# **A1 in Northumberland: Morpeth to Ellingham**

**Scheme Number: TR010059**

## **7.6E Statement of Common Ground with The Forestry Commission**

May 2021

Figure 1 - Ancient Woodland Strategy Plan

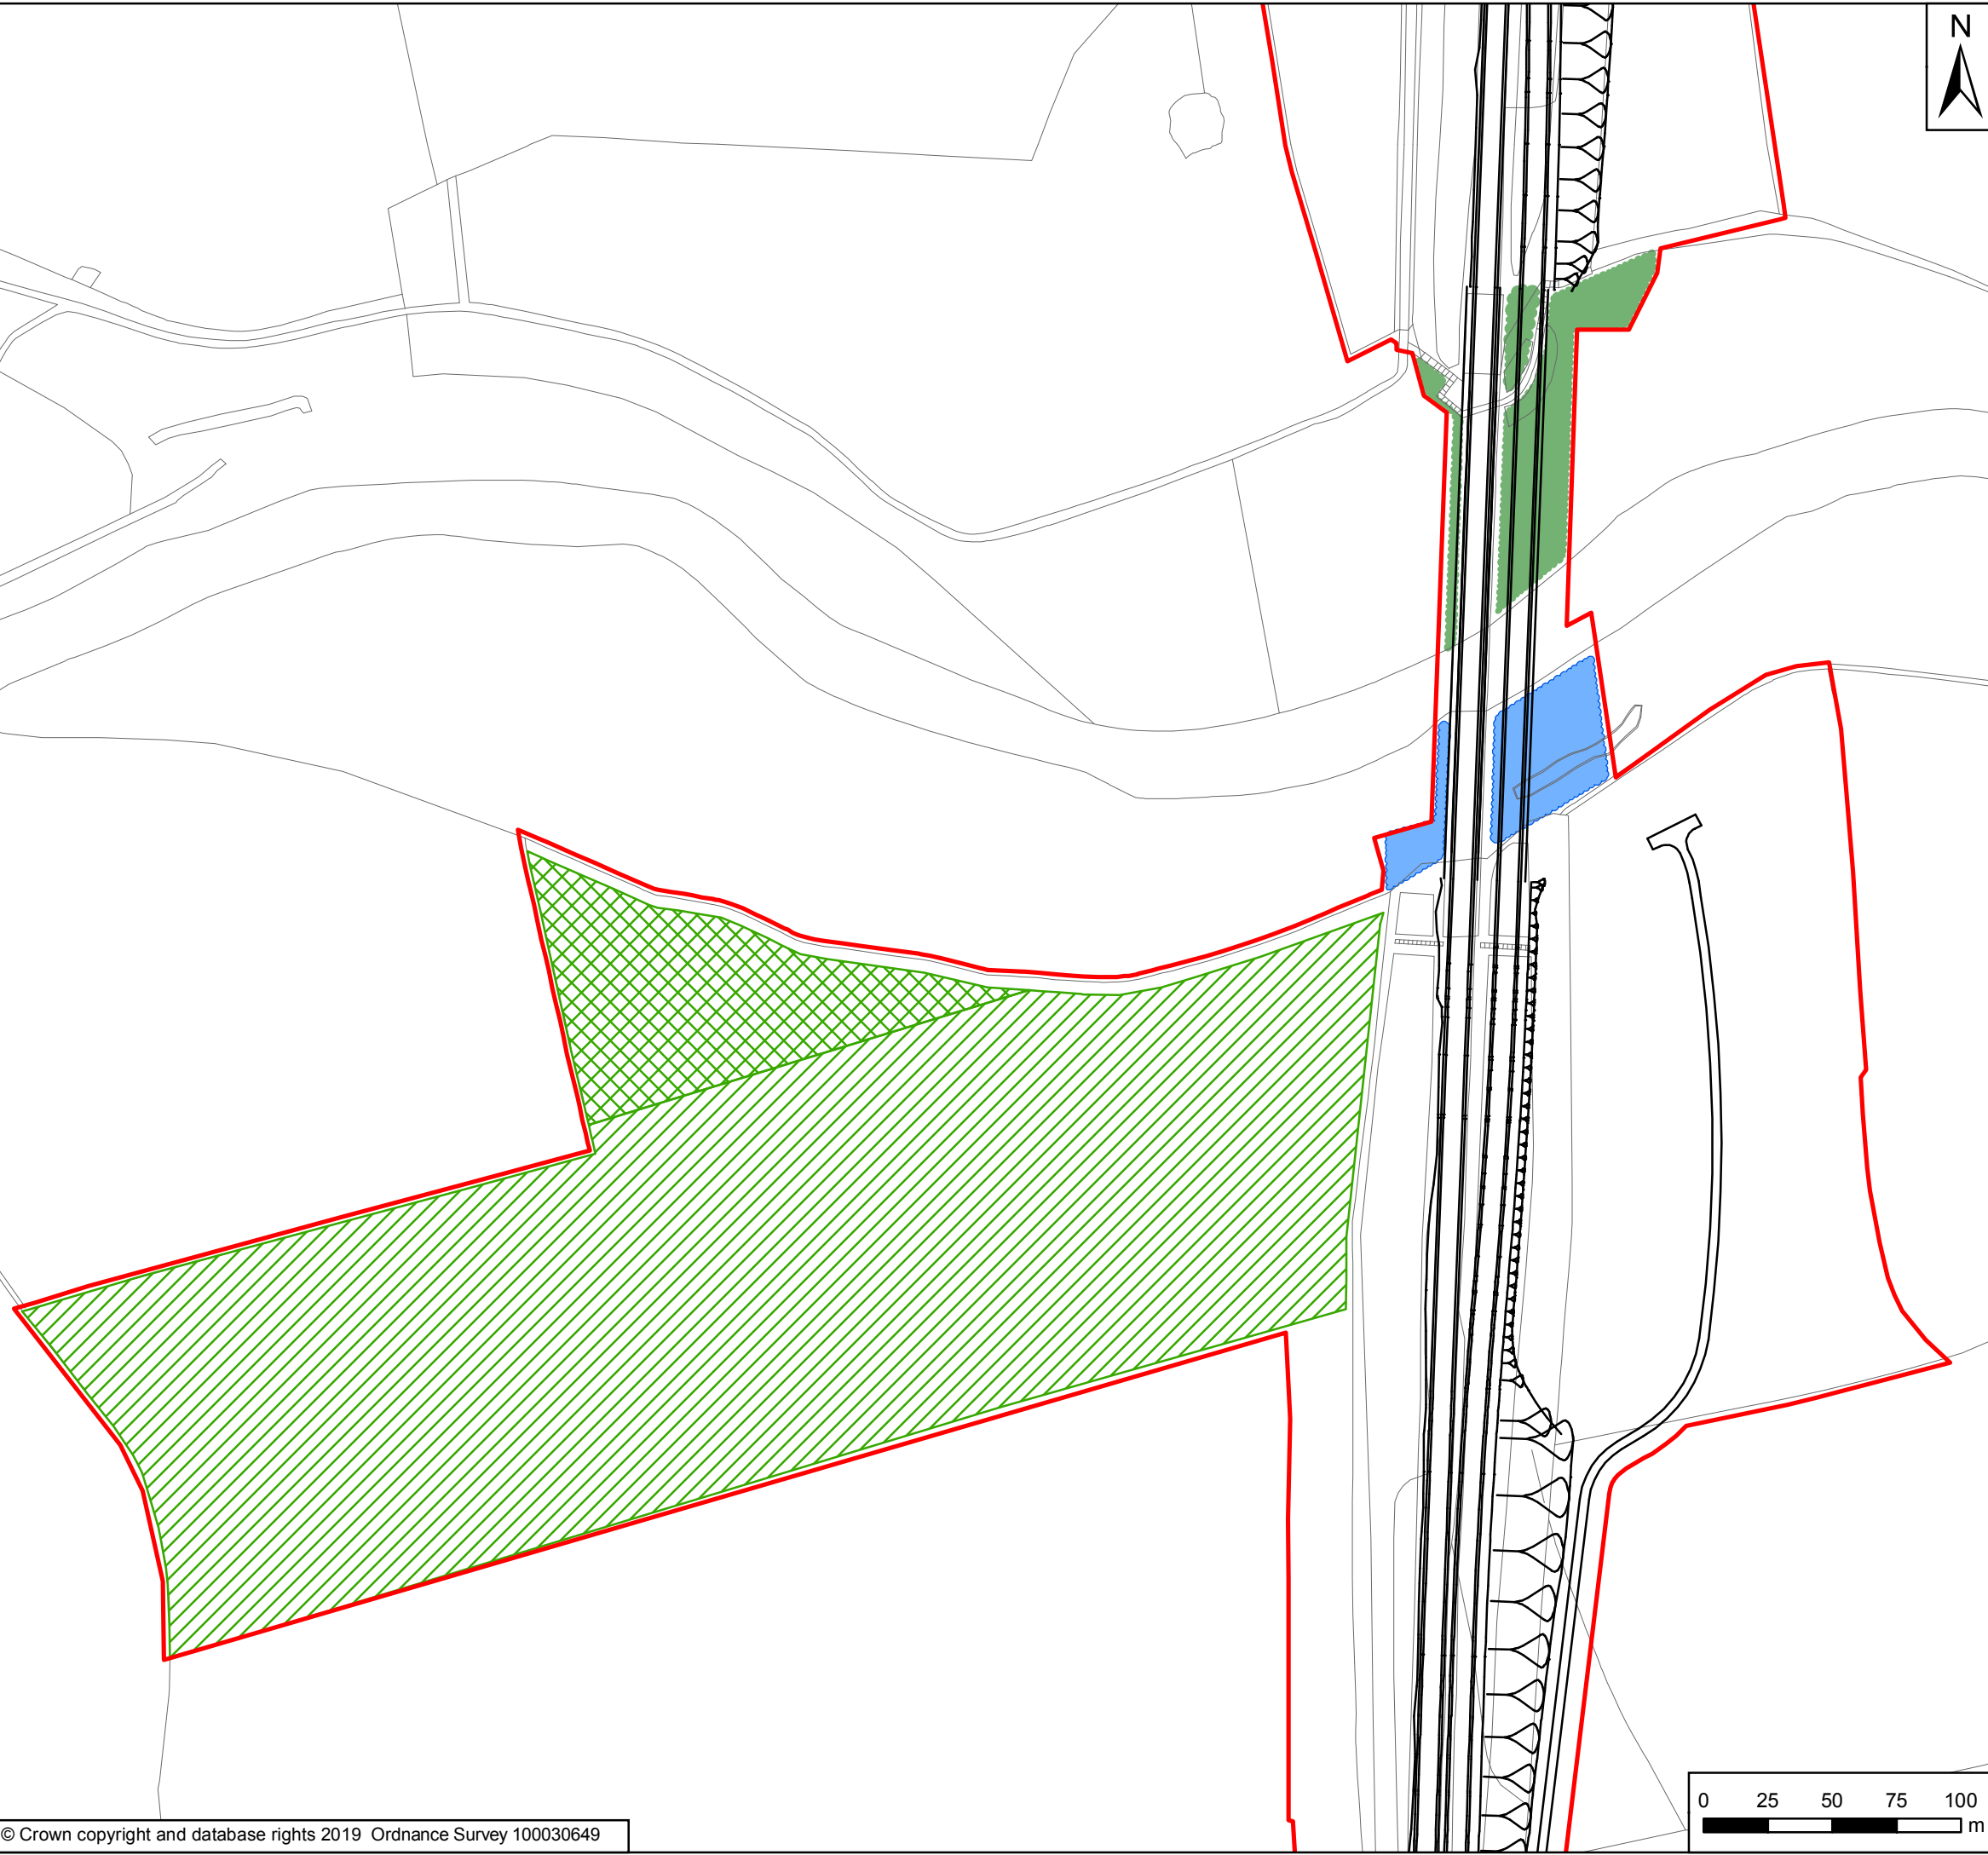
5.		Whilst it is not possible to mitigate for the loss and damage of ancient woodland, an Ancient Woodland Strategy is required to set out how the Scheme will compensate for the loss of ancient woodland.	The Applicant accepts the need to compensate for the impacts of the Scheme on ancient woodland. The Applicant has developed an Ancient Woodland Strategy [REP4-054 and 055], which details mitigation and compensation for the impacts to ancient woodland habitat.	Under discussion.

7.		<p>The Forestry Commission is satisfied that the proposed Ancient Woodland Strategy is appropriate and consider that it appropriately compensates for the impacts of the Scheme on ancient woodland. The Forestry Commission recommends that all mitigation planting and ongoing management is carried out in accordance with the <u>UK Forestry Standard</u>. Also that existing woodlands and other habitats in the local landscape of the proposed development are well considered when developing the proposed mitigation.</p> <p>The total loss of woodland for the Scheme as a whole (including 0.96 hectares of ancient woodland as defined in the Ancient Woodland Strategy [REP4-054 and 055]) is approximately 21 hectares. The proposed woodland creation to compensate for this loss is approximately 50 hectares (including the area of ancient woodland compensation planting).</p>	<p>During a meeting on 1 March 2019, Natural England agreed to the approach taken within the Ancient Woodland Strategy. This is recorded in the Natural England SoCG [REP1-029] and is captured in the Ancient Woodland Strategy [REP4-054 and 055] submitted with the DCO application.</p> <p>The submitted Ancient Woodland Strategy would be secured through measures A-L6, A-B3, A-B42, A-B43, A-B44, SW-L1, and SW-B6 of the Register of Environmental Actions and Commitments contained within the Outline Construction Environmental Management Plan (Outline CEMP) [REP7-008 and 009] (and as updated at Deadline 8) and Requirement 5 of the draft DCO [REP6-010 and 011].</p>	Under discussion.
